Sewall Wetland Consulting, Inc.

October 30, 2019

RE: 5637 East Mercer Way – Parcel #1924059312
City of Mercer Island, Washington
SWC Job#14-206

This letter is a response to your September 23, 2019 email to Bill Summers regarding permitting related to Parcel #1924059312.

Wetland and Wetland Buffer Impact Site Plan

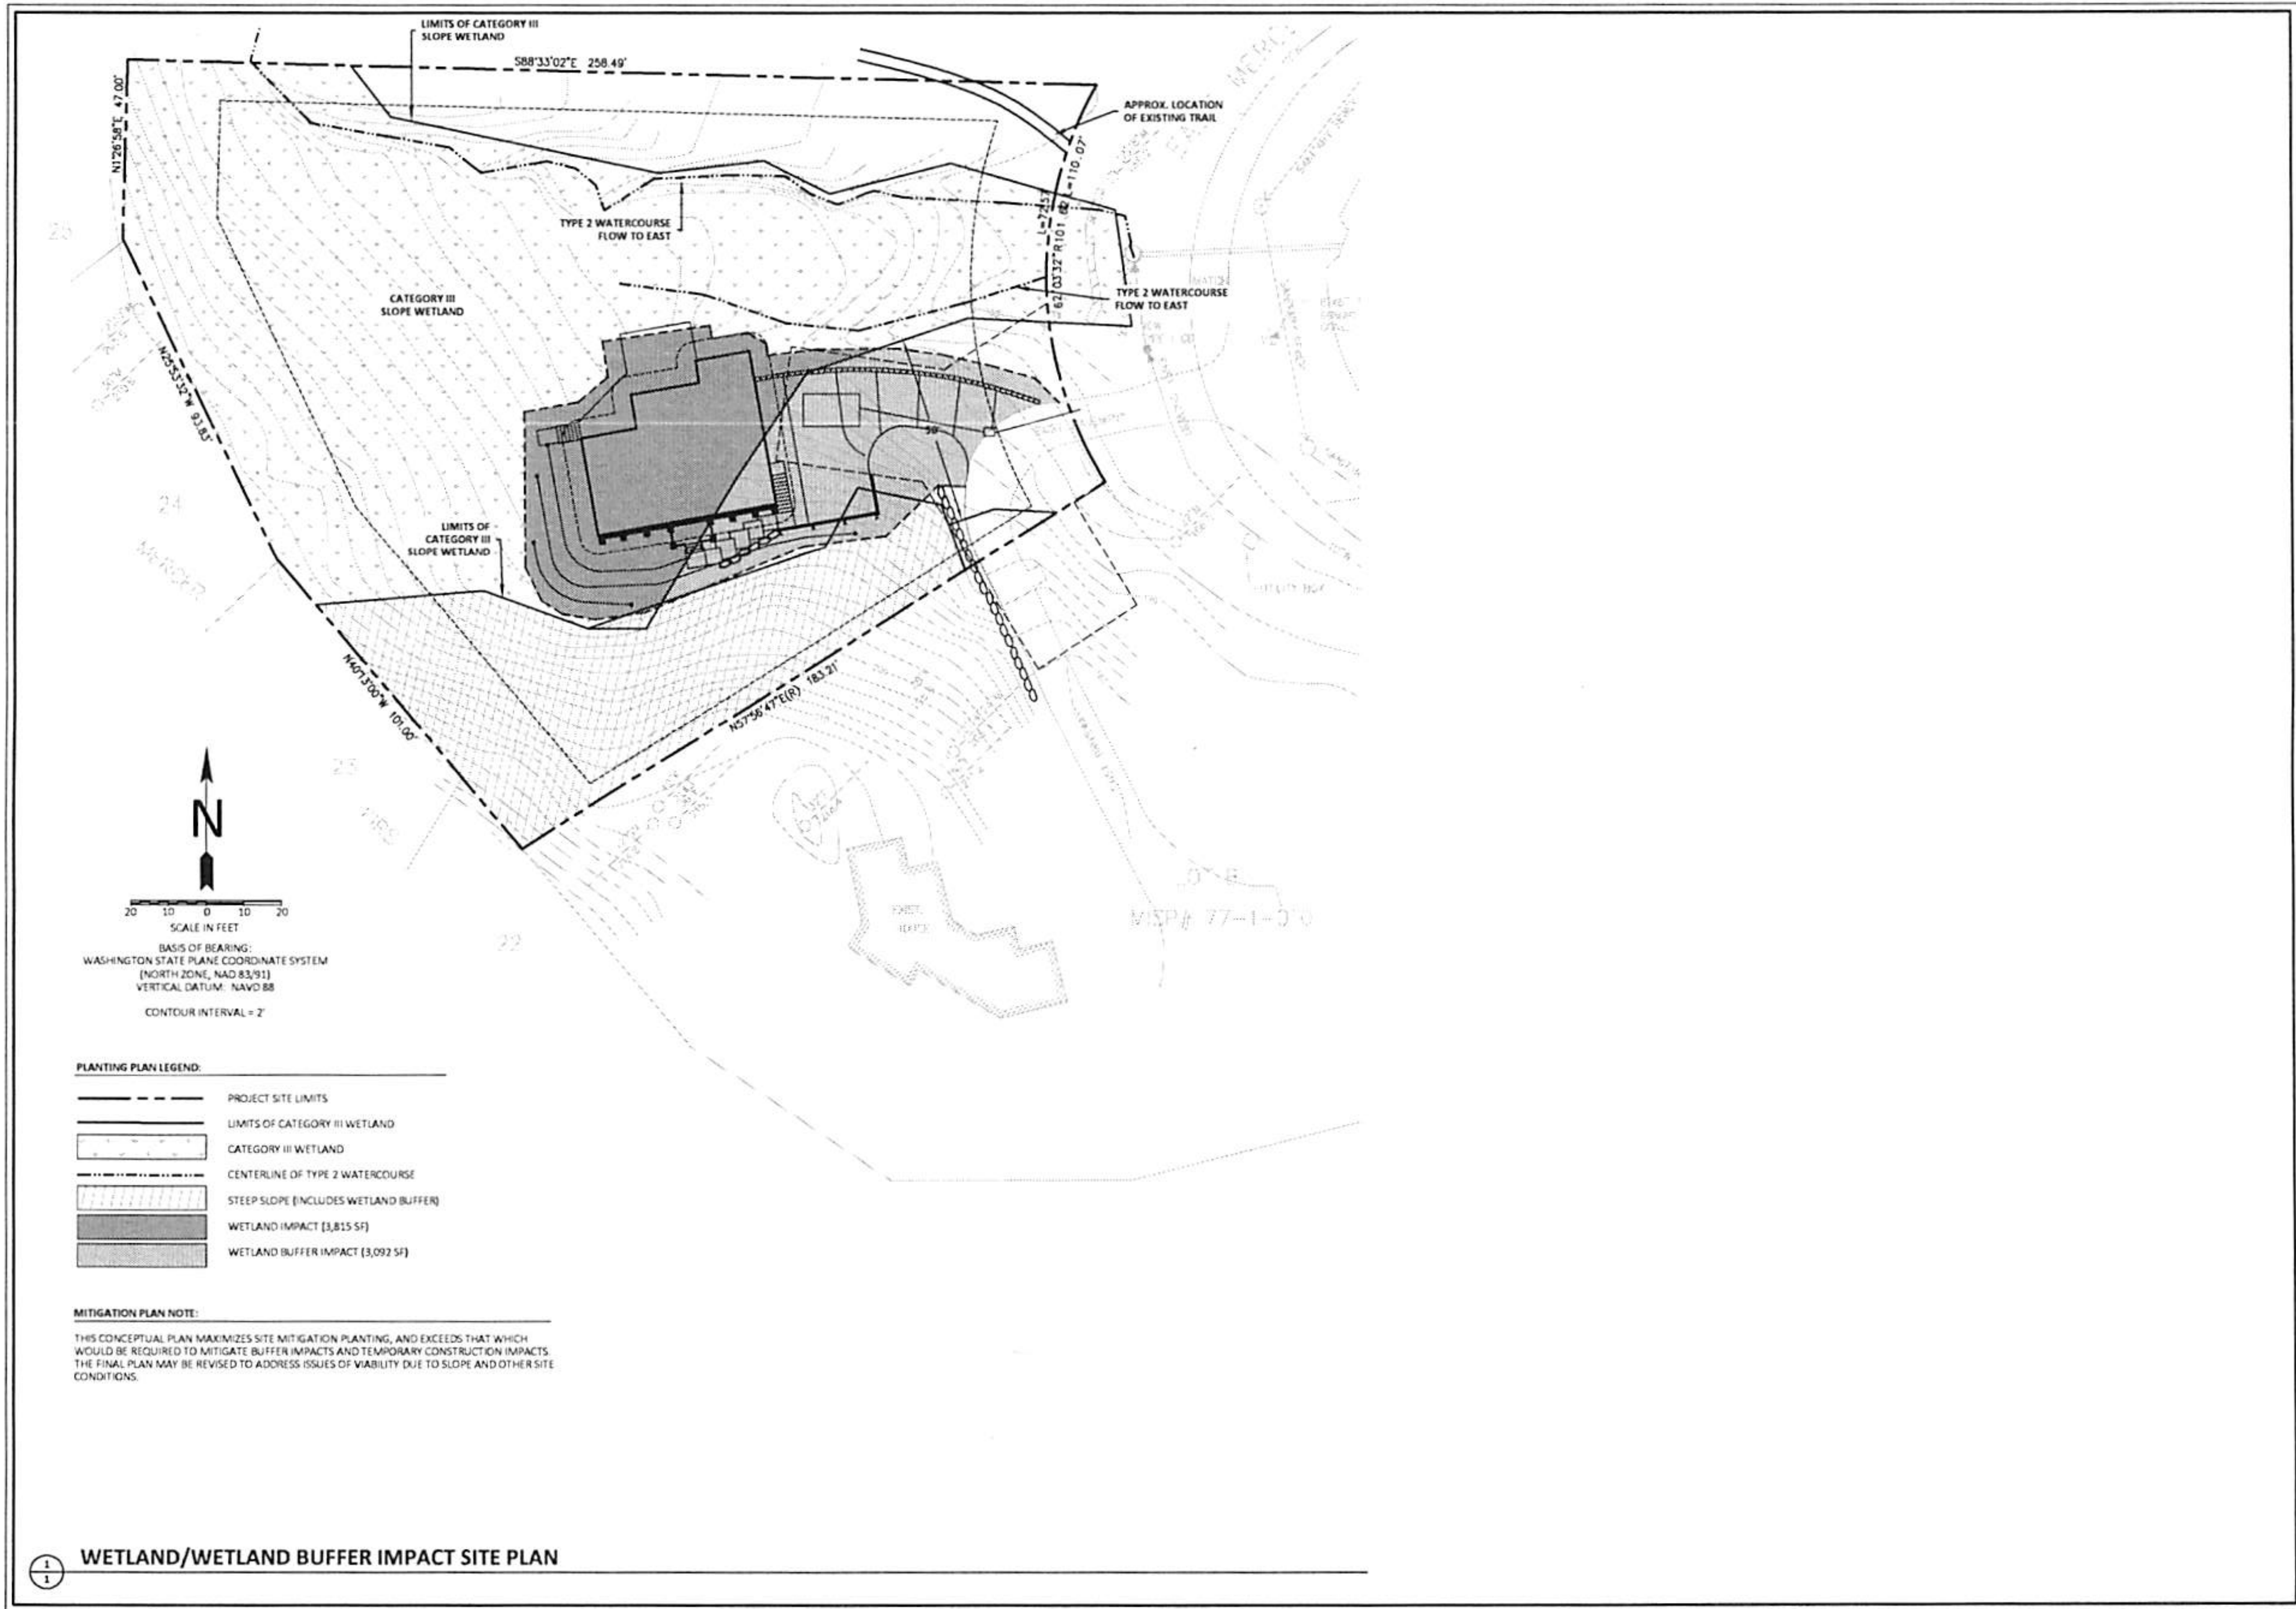
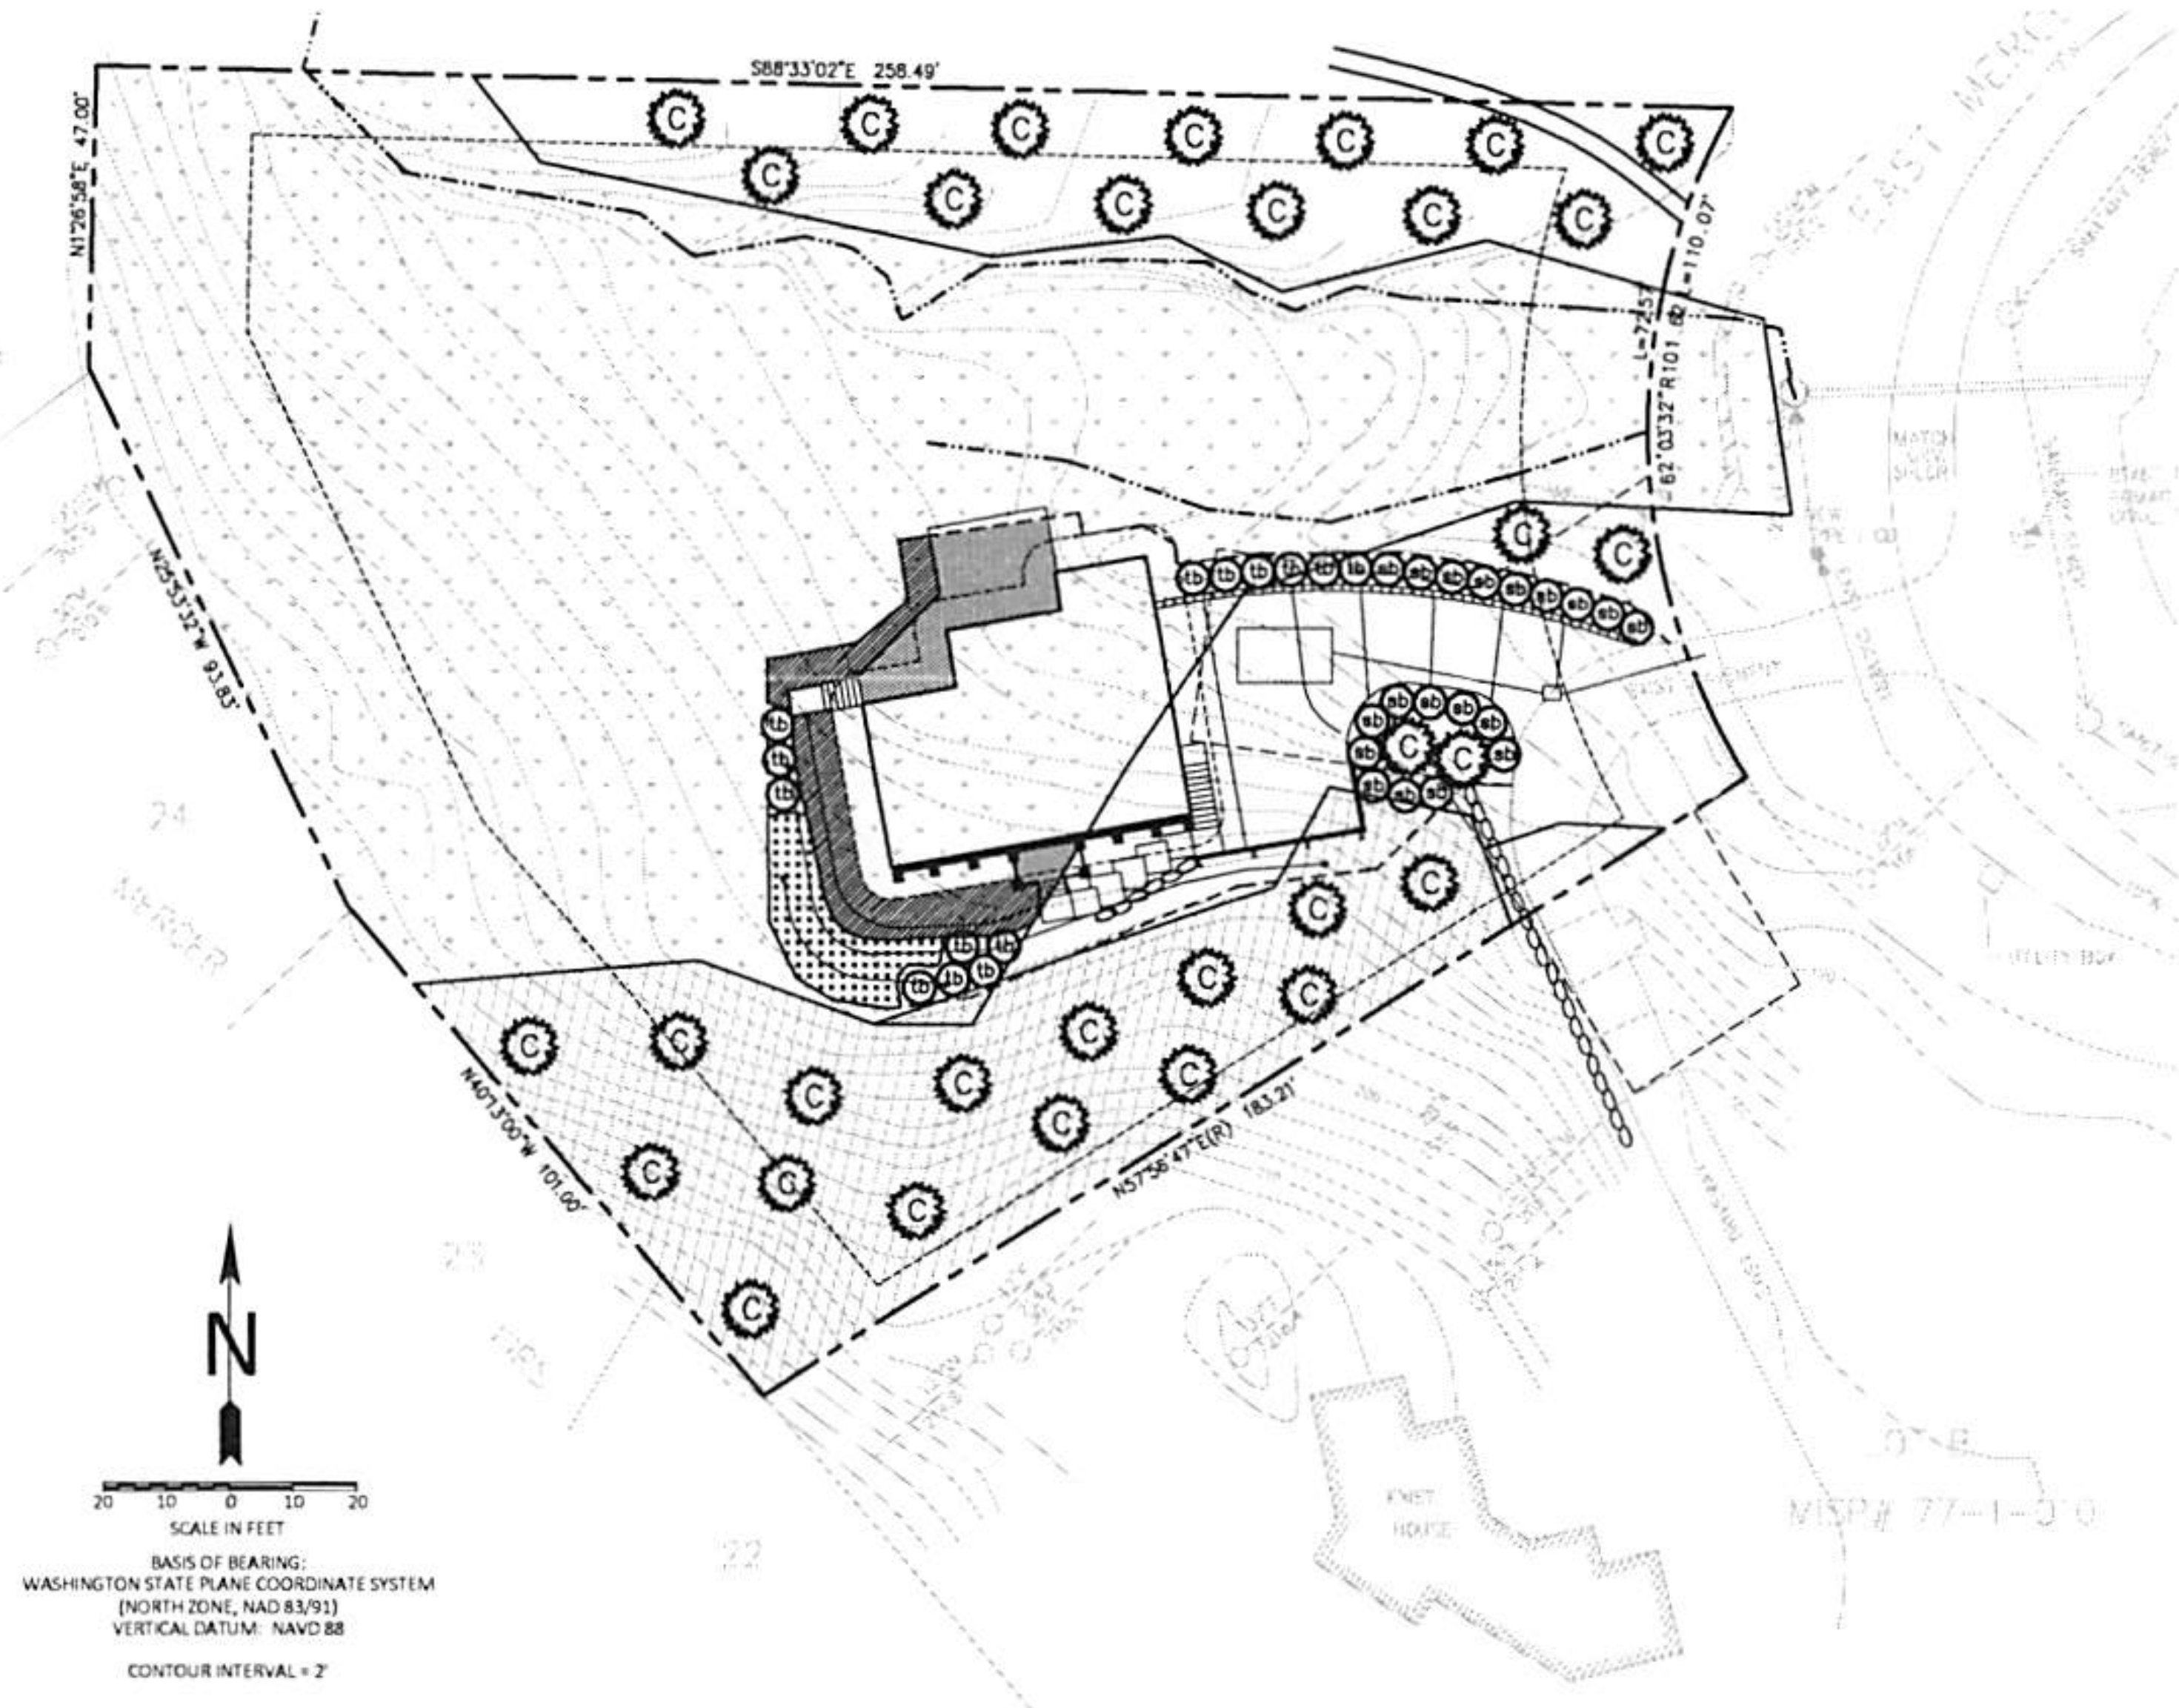
Mr. Anderson noted that the proposed grade of the garage floor, as shown on Sheet 1, 2018 Site Plan Wetland & Buffer Disturbance (The Healy Alliance AZ, 2018) is located below existing grade at the southwest corner of the house. The garage floor is located at 179.5 feet, the grade at the southwest house corner is 185 feet, and the grade at the backside of what appears to be a retaining wall is 193 feet. Although not shown on the plans, it is likely that a drainage system will need to be installed on the backside of retaining wall and adjacent to the building foundation to alleviate static pressure on these structures by transporting groundwater down-gradient. The retaining wall drainage system would likely impact wetland hydrology up-gradient of the wall by acting as a groundwater "sink." Similarly, the foundation drainage system would impact wetland hydrology adjacent to the of the building (i.e., southwest). The extent and degree of impact to wetland hydrology is unknown at this time and ESA is not qualified to make this determination. ESA recommends that design plans detail the proposed drainage system for the project and the City consult a hydrogeomorphologist to determine likely impacts to wetland area.

Mr. Anderson also discussed a stormwater detention tank that was depicted on previous plan sheets immediately east of the building, underneath the proposed driveway. The applicant did provide preliminary stormwater calculations for this tank; however, Sheet 1, 2018 Site Plan Wetland & Buffer Disturbance (The Healy Alliance AZ, 2018) does not show a stormwater tank. Mr. Anderson points out that the tank's proximity to the wetland boundary and required excavation to install may have a negative impact on wetland hydrology. The area around the tank may need to be backfilled with coarse material and drainage may need to be provided to address buoyancy of the tank. Should continuous drainage of the area surrounding the tank be required, this project element may act as a "sink" similar to the drainage system discussed above. ESA recommends the applicant provide additional details on the stormwater detention tank to address the potential for indirect impacts to the adjacent wetland.

Response: It is our opinion that the proposed site plan and foundation drainage system will not impact hydrology of the wetland. Surface seepage of the slope wetland upslope of the proposed home contains soils that do not appear prone to drainage or creating a "sink effect" as it would in a more permeable soil type. Water that seeps through this

Response: It is our opinion that the proposed stormwater tank under the driveway will not impact wetland hydrology or functions from the construction or use of the tank. Water within the wetland in this area appears to be seeping to the east and not influenced by the area of dense fill to the south where the gravel driveway currently exists.
